Addendum No. 1

RE: Contract # C203792

Guilford County (U-2524D)

Greensboro Western Loop – From US-220 (Battleground Avenue)

SUMMARY OF PHASE CONSTRUCTION

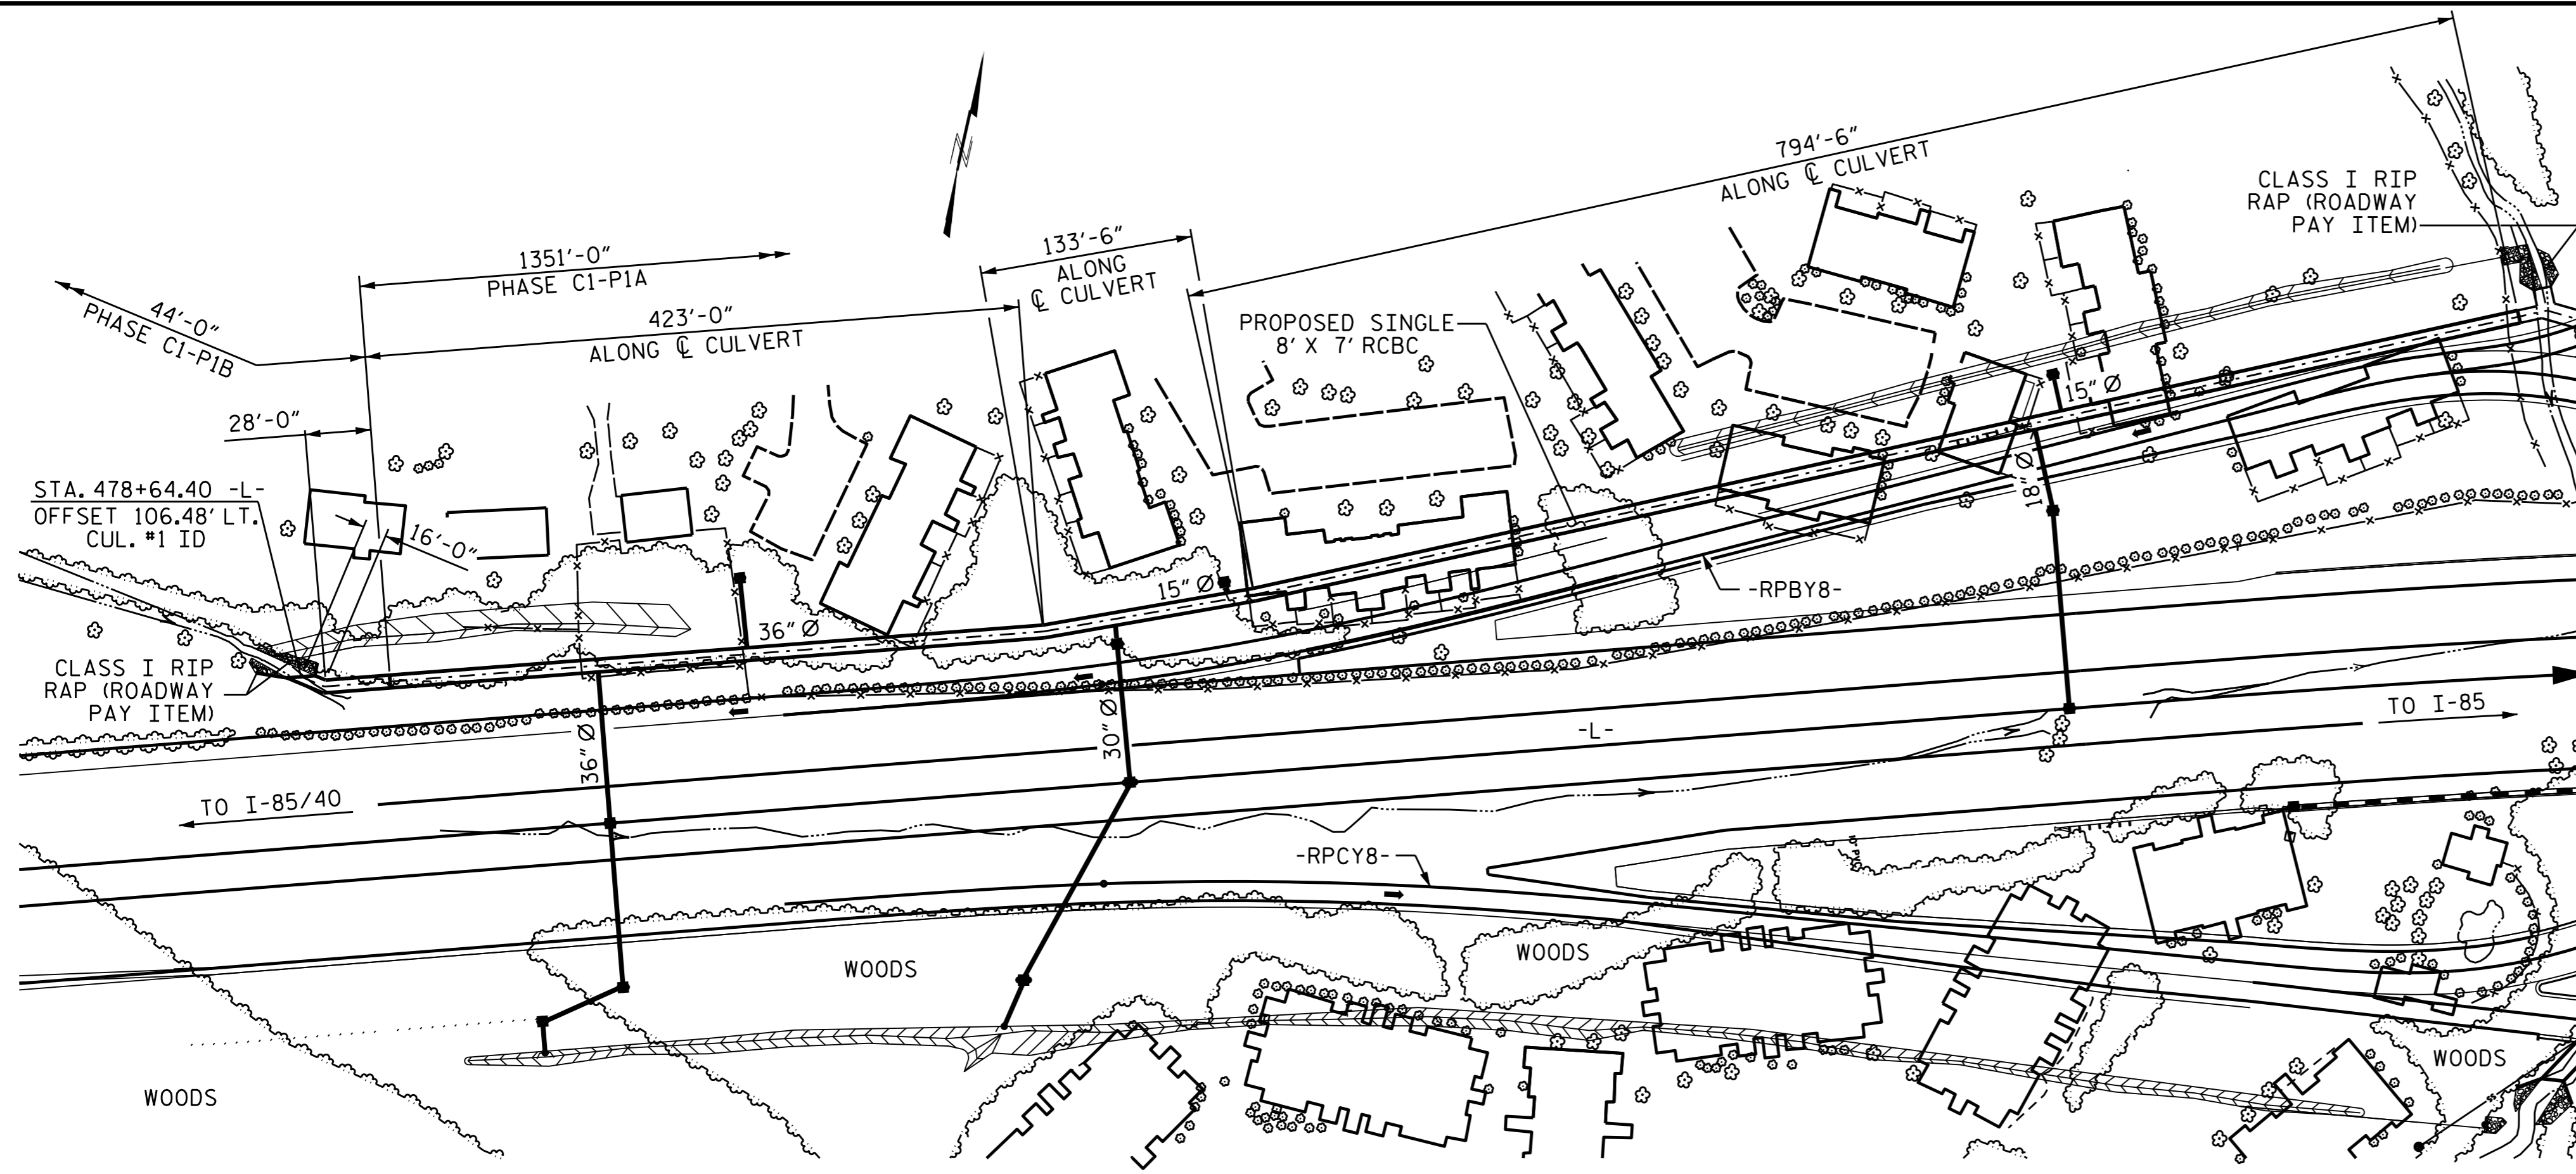
Sheet No.	Revisions
Summary of Construction Sheet	Added North Arrow
C-1	Added Control line reference on profile along centerline of Culvert
C-2	Added reference at top right "See Plan of Culvert #2 and Section D-D on Sheet C-8 For Details"
C-7	Eliminated note about backfilling the culvert depth to depth of 1 foot, etc.
C-8	Corrected orientation of -Y8- line relative to culvert centerline
C-14	Corrected profile along centerline of Culvert to reflect existing ground profile; added control line reference on Profile Along Centerline of culvert; added note for culvert falsework/formwork submittal requirements; added note for construction of pipes through culvert sidewalls
C-15	Changed construction joint to "Permitted" construction joint in Section along centerline of culvert; in Section A-A changed construction joint to
